Application number: 2020/94123	
What is the application for?:	Erection of extensions and alterations to front, side and rear, formation of rai
Address of the site or building:	2, Little Lane, Wooldale, Holmfirth, HD9 1QF
Postcode:	HD9 1QF

Type of comment: An objection	
Do you wish your comments to be published on the website anonymously?	No

PROPOSED SITE PLAN
SCALE 1:200

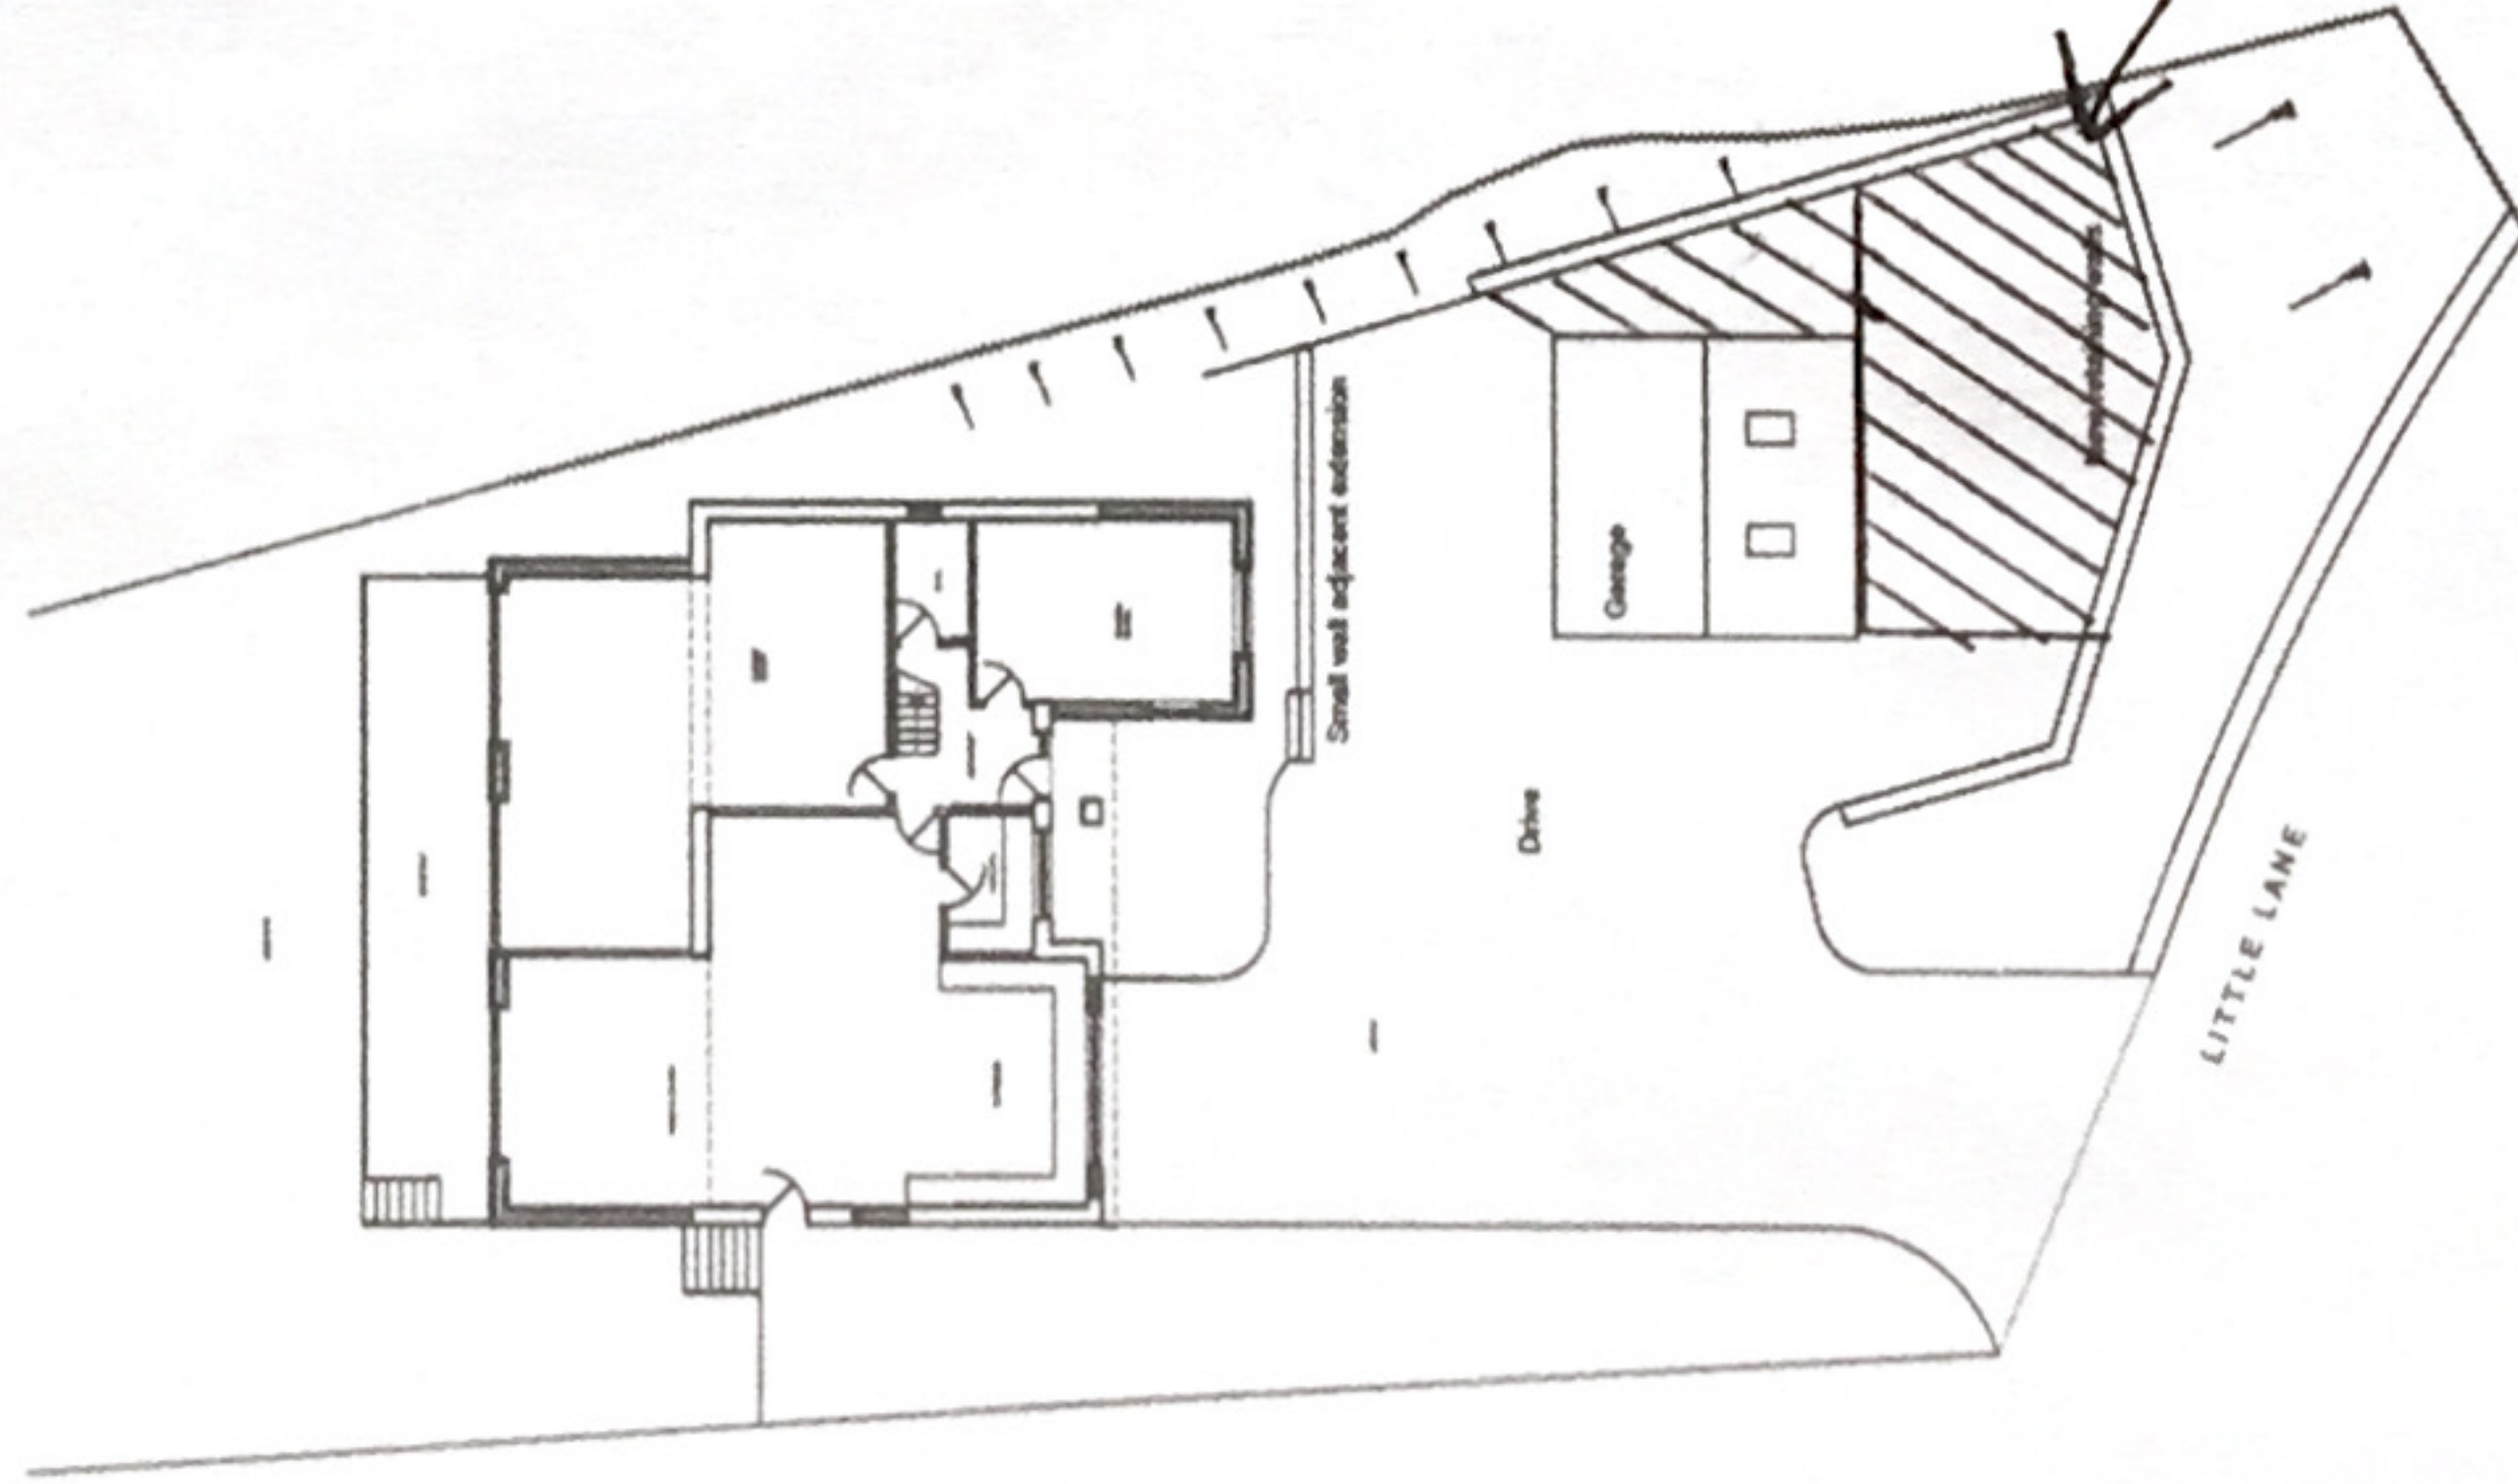
The erection of the separate garage and the tarmacked forecourt in front of the house is not in keeping with the other houses on Little Lane, which have mature gardens and an open aspect. As previously stated, the deeds stipulate that building in the front garden is prohibited. If this was allowed to continue, this sets a precedence for future developments and will negatively alter the appearance of the whole road and the village. It is surprising that this work has been permitted to begin without notification.

The removal of the large front garden for the extensive excavations for the garage, forecourt and retaining walls will only add to the existing issues of runoff. Little Lane has historically had problems of excess surface water from the park and underwater springs. This could cause flooding lower down the hill on Little Lane and its neighbouring properties.

PROPOSED FRONT ELEVATION
SCALE 1:100

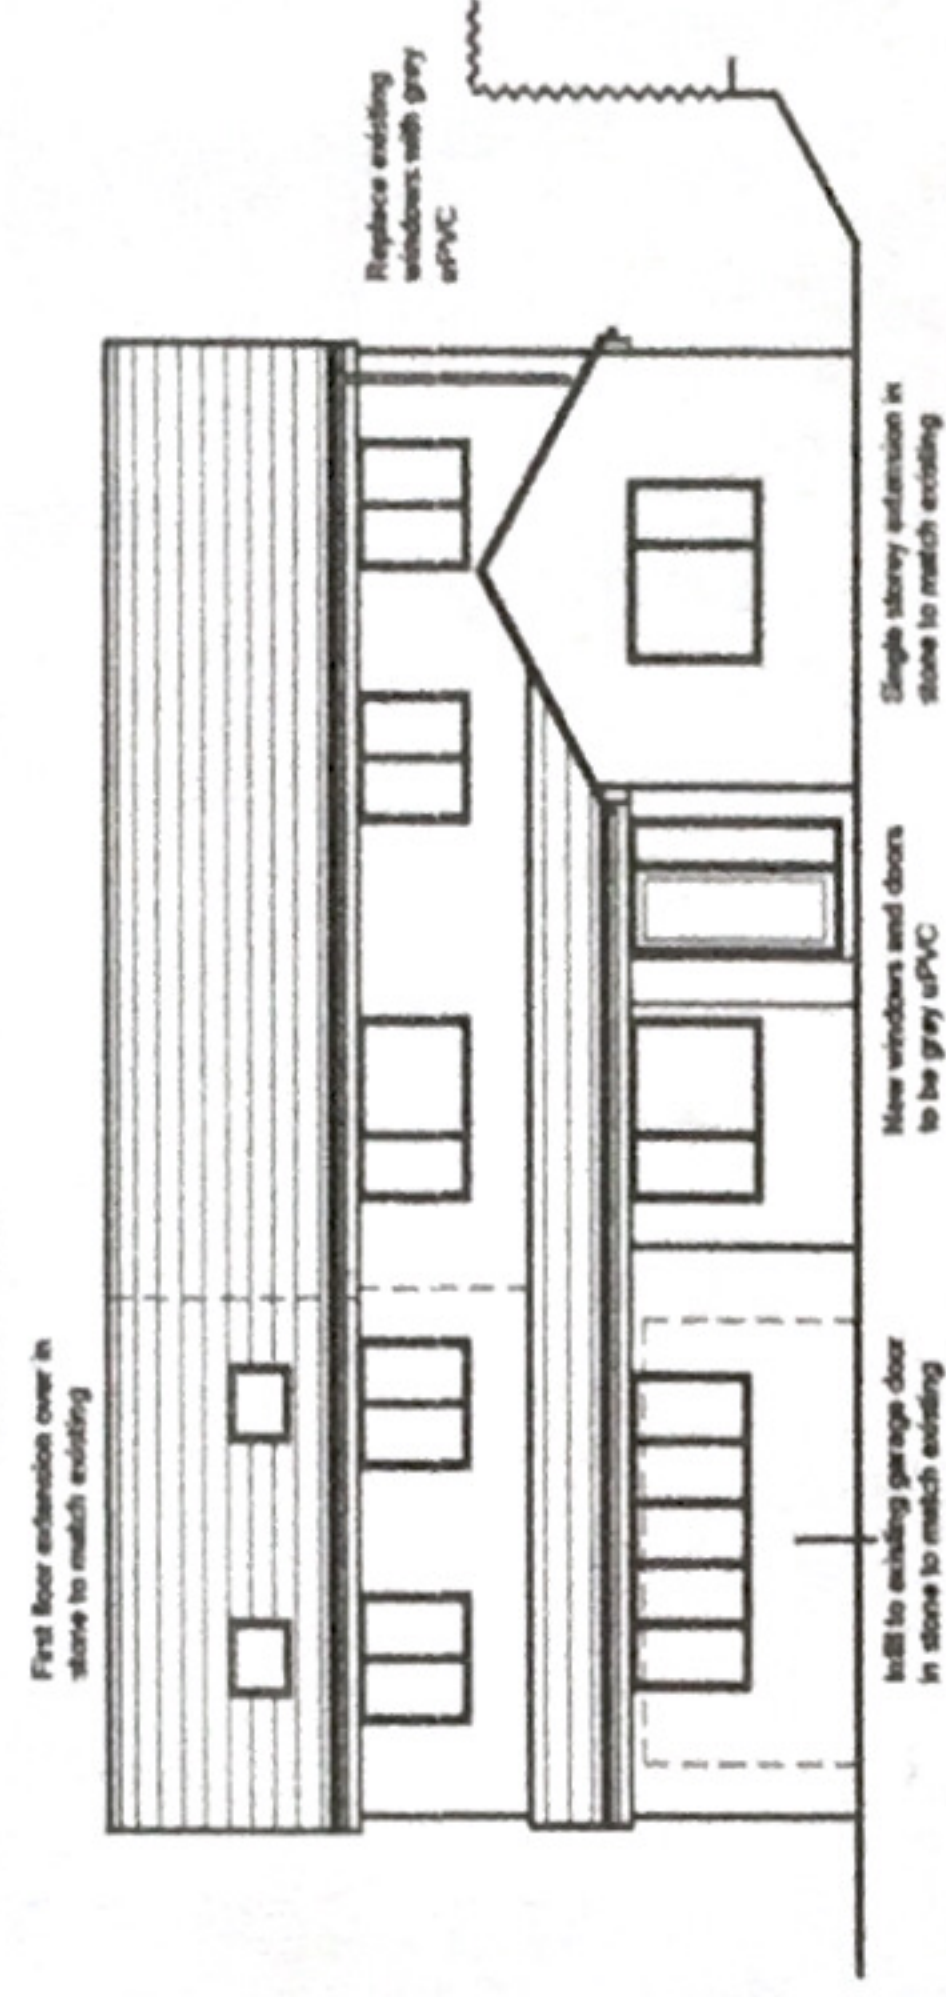
The overbearing size, scale and design of the planned extension of the house remains an issue and is not sympathetic to neighbouring properties in the village. It is overlooked by Wooldale Park, an attractive recreational space within the Conservation Area. The extension over the current garage will intrude on the panoramic views of the surrounding hills, not only from the park but the village itself.

The use of alternative materials and extensive rendering will adversely impact on the visual unity in design of the existing properties on Little Lane and the surrounding area and will be a significant change to the distinctive built character of the area.
